Martin J. Chávez, Mayor

RE: Engineer Certification for Lot 14-A-3 Midway Business Park (E17-D41M) Certification
Statement dated 9/10/96.

RE: DRAINAGE PLAN FOR LOT 14-A-3 MIDWAY BUSINESS PARK
(E17-D41M) ENGINEER'S STAMP DATED 12/27/95.

MIDWAY PARK OFFICE BUILDING GRADING and DRAINAGE PLAN

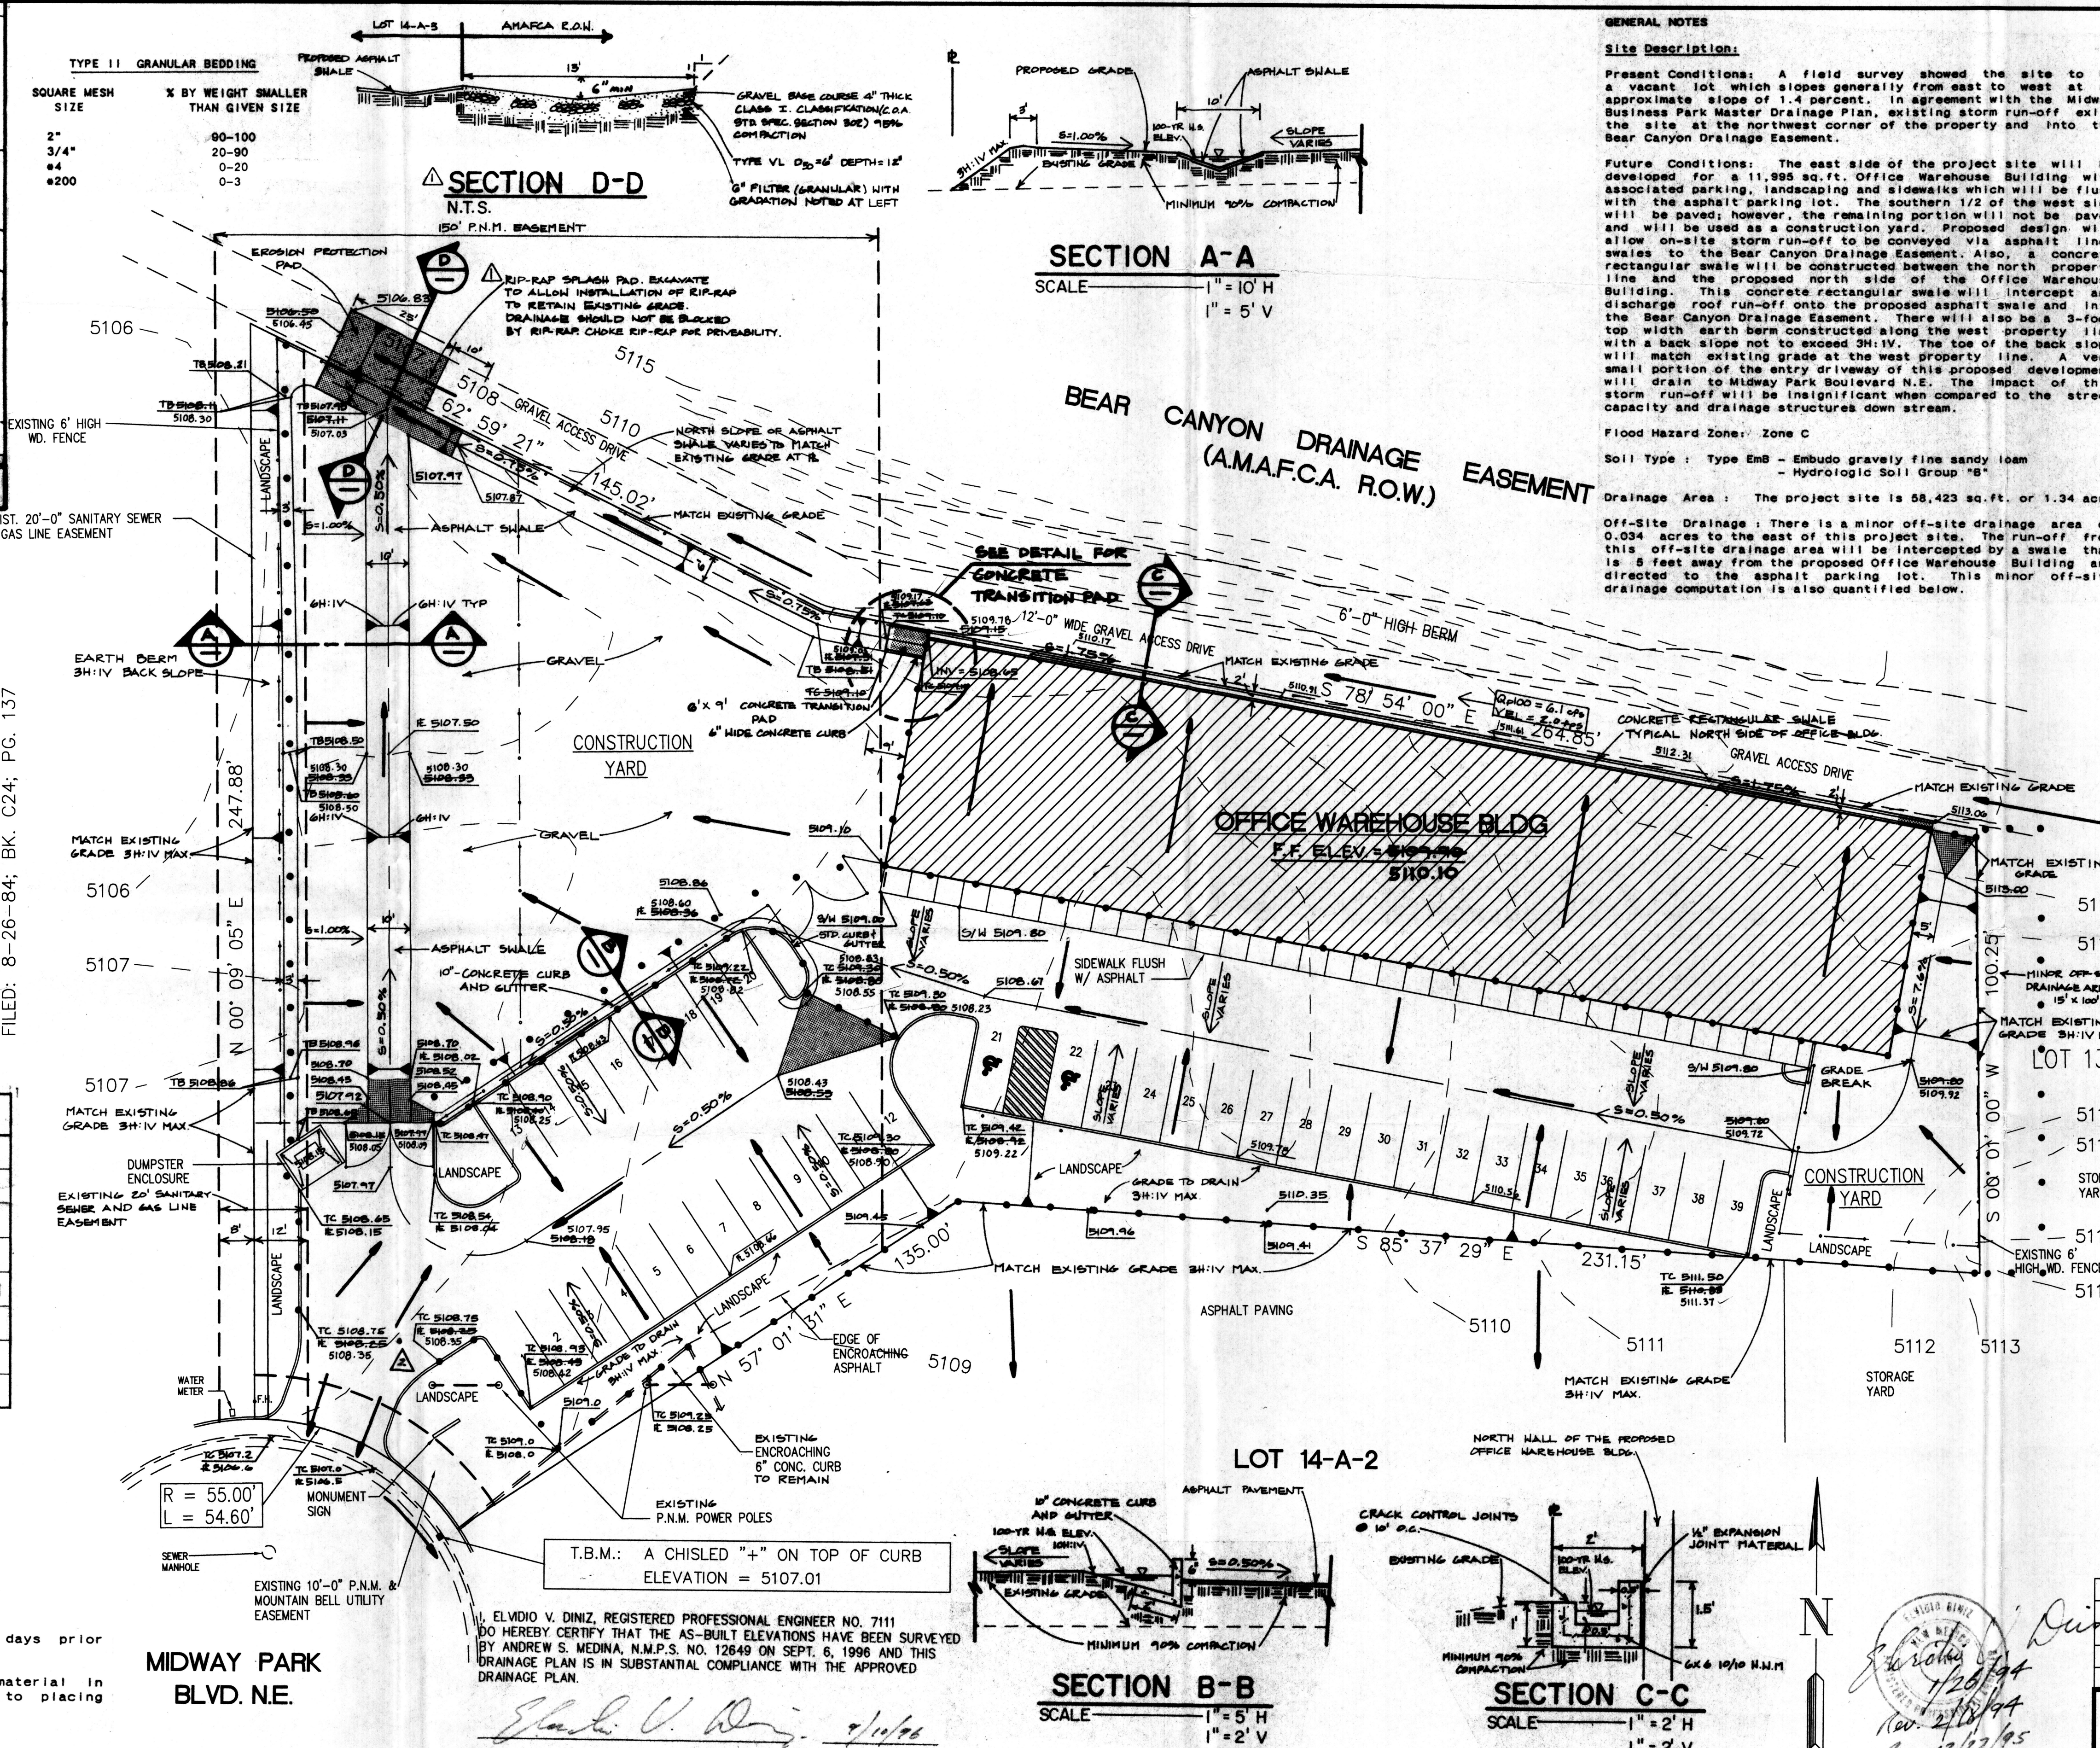
1. Concurrence from AMAFCA in writing for work done within their R/W.
2. Legend must include the designation for the as-built information.
